**Colorado Springs, CO
Planning and Development**

**Final Report - Corrections Required
Application No. DEPN-22-0222**

Description : A new 53 unit apartment complex
Address : 0 8th ST Colorado Springs CO 80905
Record Type : Development Plans
Document Filename : 3rd Submittal_Development Plan

DESIGNED BY QNA
DRAWN BY QNA
CHECKED BY
H-SCALE AS NOTED
V-SCALE NA
JOB NO. 2089.00
DATE ISSUED 01/12/23
SHEET NO. 4 of 11

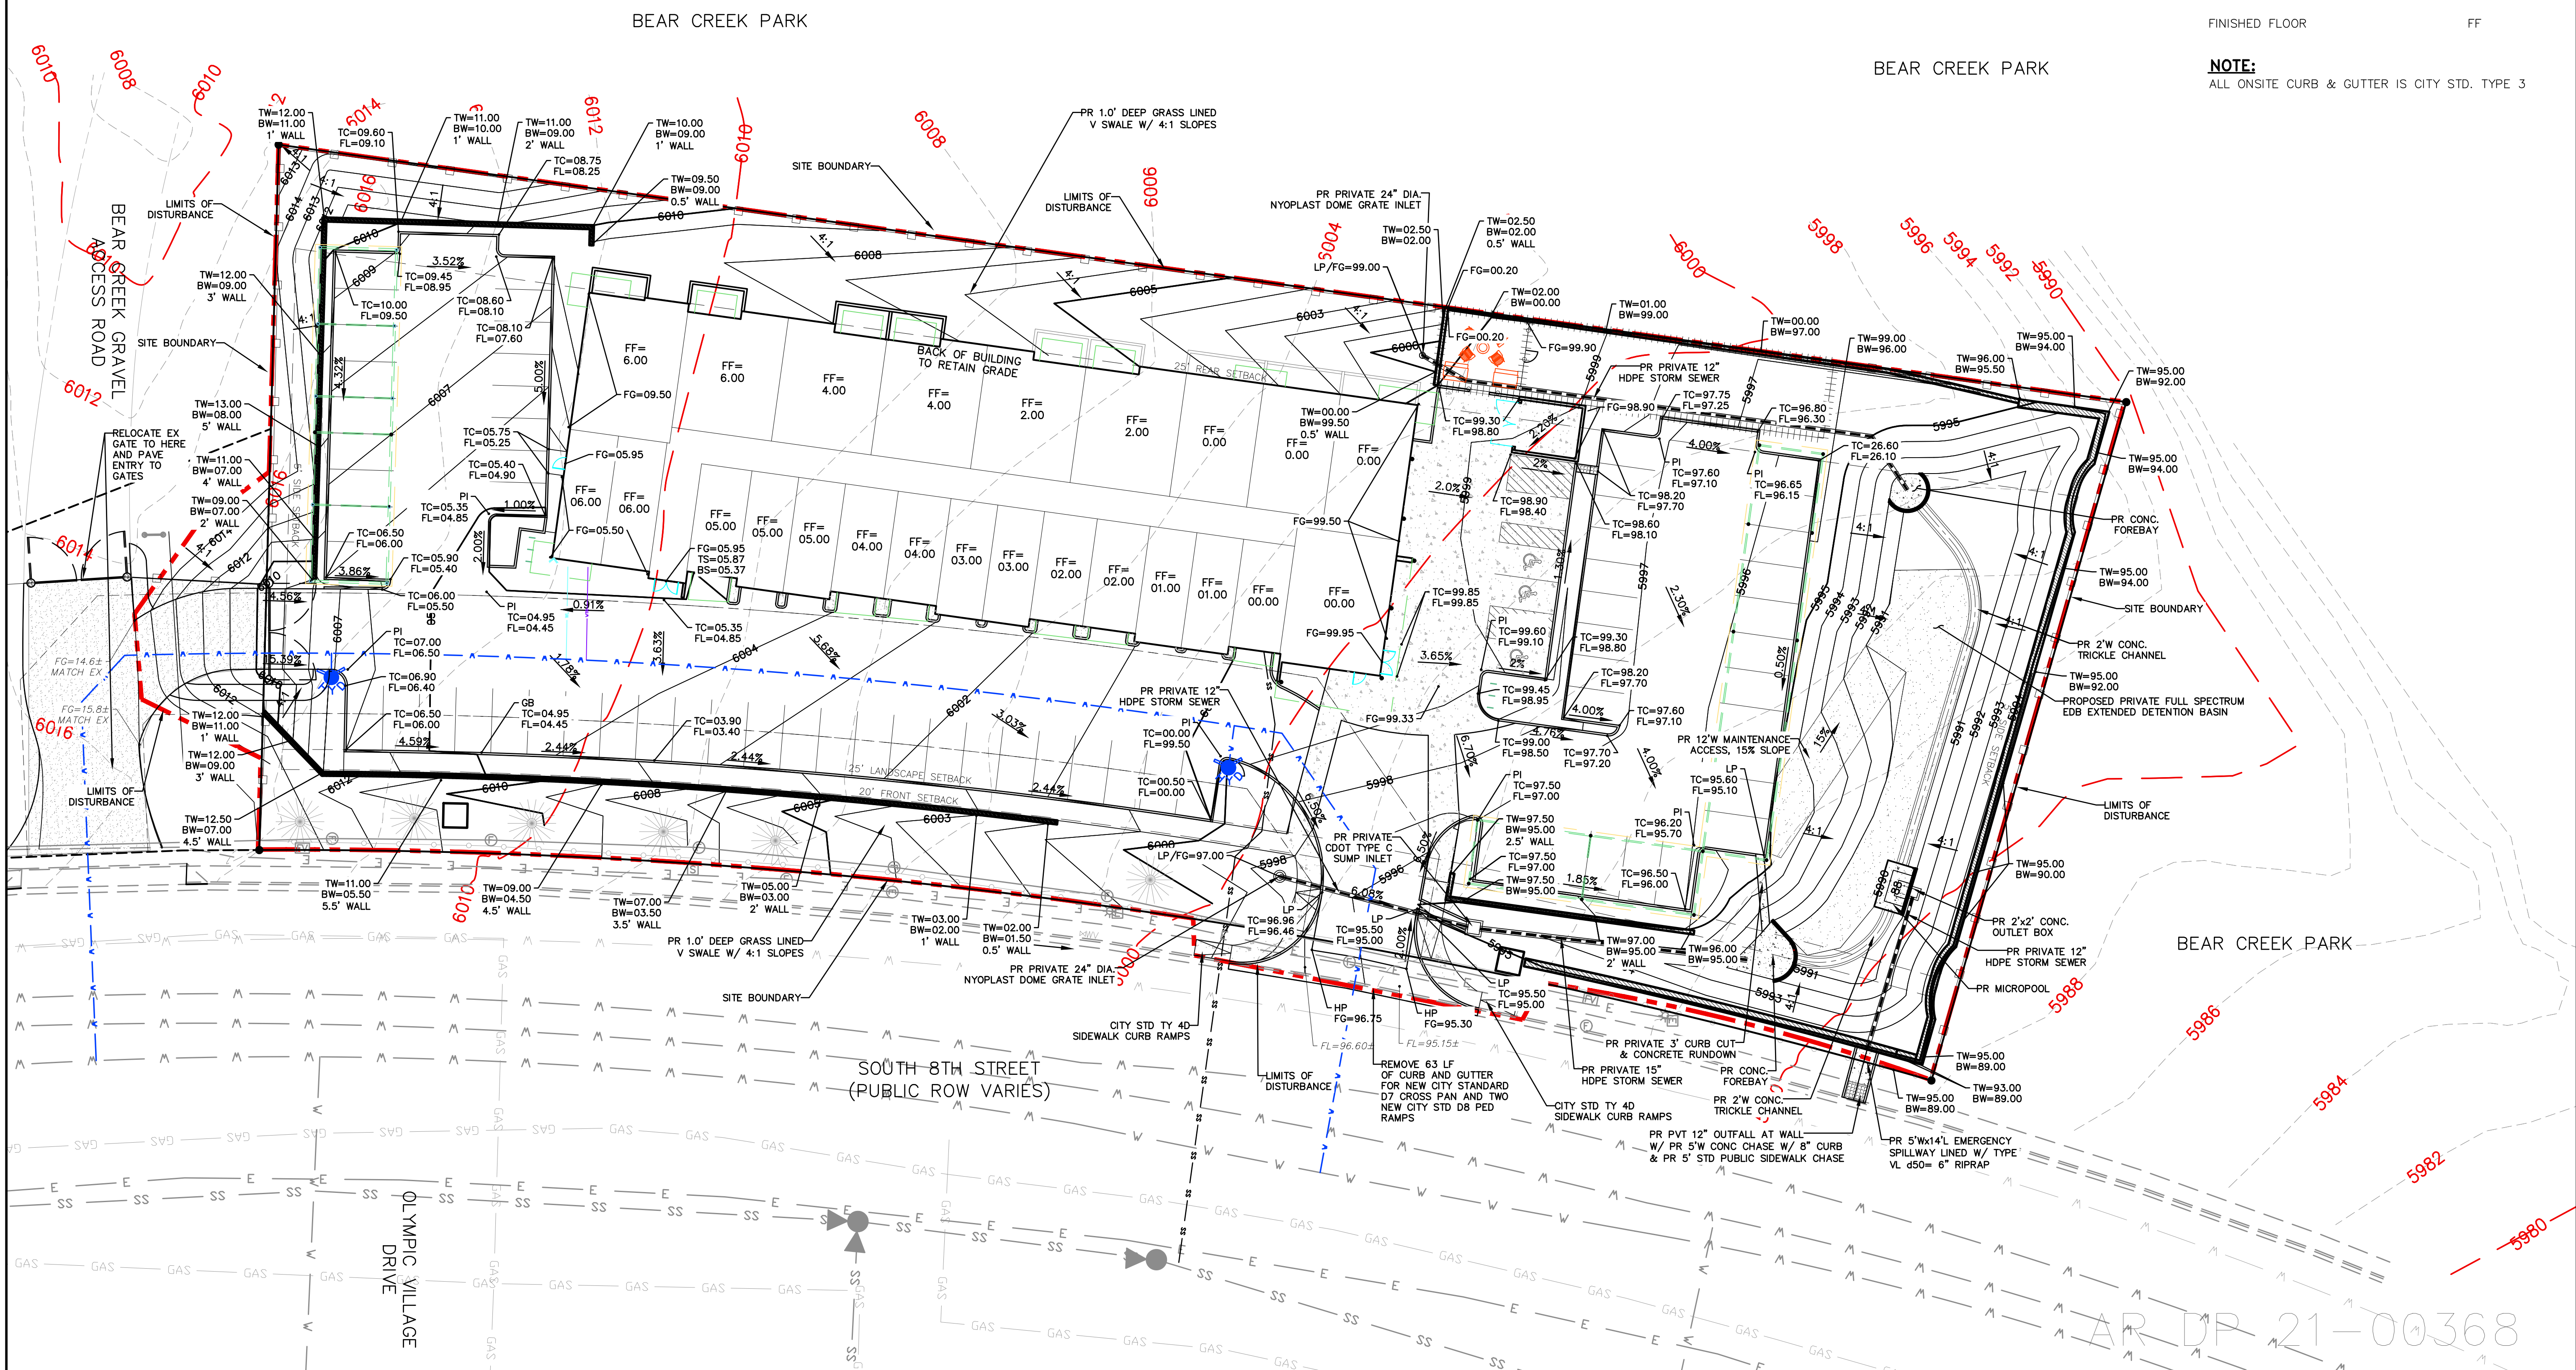
Comment ID	Page Reference	Author : Department	Review Comments
42	4	Hao Vo : City Engineering - SWENT	Per the approved FDR, this inlet is a 12' D10-R inlet. Revise to match.
43	4	Hao Vo : City Engineering - SWENT	Per the approved FDR, the maintenance access path does not extend to the East forebay. Revise to match.
44	4	Hao Vo : City Engineering - SWENT	Please show and label the emergency spillway.
45	4	Hao Vo : City Engineering - SWENT	The layout of the western storm network outfalling to the West forebay does not match what is shown in the approved FDR. Revise to match.
46	4	Hao Vo : City Engineering - SWENT	Per the approved FDR, this portion of the maintenance path has a slope of 12%. Revise to match.
47	4	Hao Vo : City Engineering - SWENT	The pipe layout connecting to the pond outfall do not match what is shown in the FDR. Revise to match.
48	4	Hao Vo : City Engineering - SWENT	Is there a proposed swale in the parking median north of the proposed building?

50	4	Hao Vo : City Engineering - SWENT	Please show and label all easements on all sheets with ownership (private/public), width (or state "width varies"), and type.
49	8	Hao Vo : City Engineering - SWENT	Please revise the text conflict on sheet 8.
55	1	Joel Dagnillo : City Engineering Dev Review	Add "potentially unstable slopes" to list of hazards in this statement.
56	1	Joel Dagnillo : City Engineering Dev Review	Please address all comments in CGS's review letter (dated December 21, 2022), revise the geological hazard report accordingly, then resubmit to the City.
41	5	Corey Masoumi : Col Springs Utilities	What is this? is it a T-wall? if it is a T-wall, it cannot be in our easement.
52	1	Matthew Alcuran : Planning	<p>El Paso County Park Comments:</p> <p>When construction commences, no construction activity may take place outside of the apartment property or the access easements we are providing. This means that staging, overburden, construction traffic, and workman egress cannot take place on EPC Park property. EPC parks understands that a retaining wall and other amenities will be located close to the property line. If Viceroy needs a temporary access agreement for construction activities, please advise EPC as soon as possible This agreement would allow (for instance) perhaps a 10-foot buffer around the property and the affected ground restored and reseeded. Erosion control measures would need to be utilized so construction material does not migrate into Bear Creek Park or the Equestrian Skills Course, which lies very close to the northwest corner of the property. EPC wants to ensure the property is protected and the project can move forward with no issues.</p>
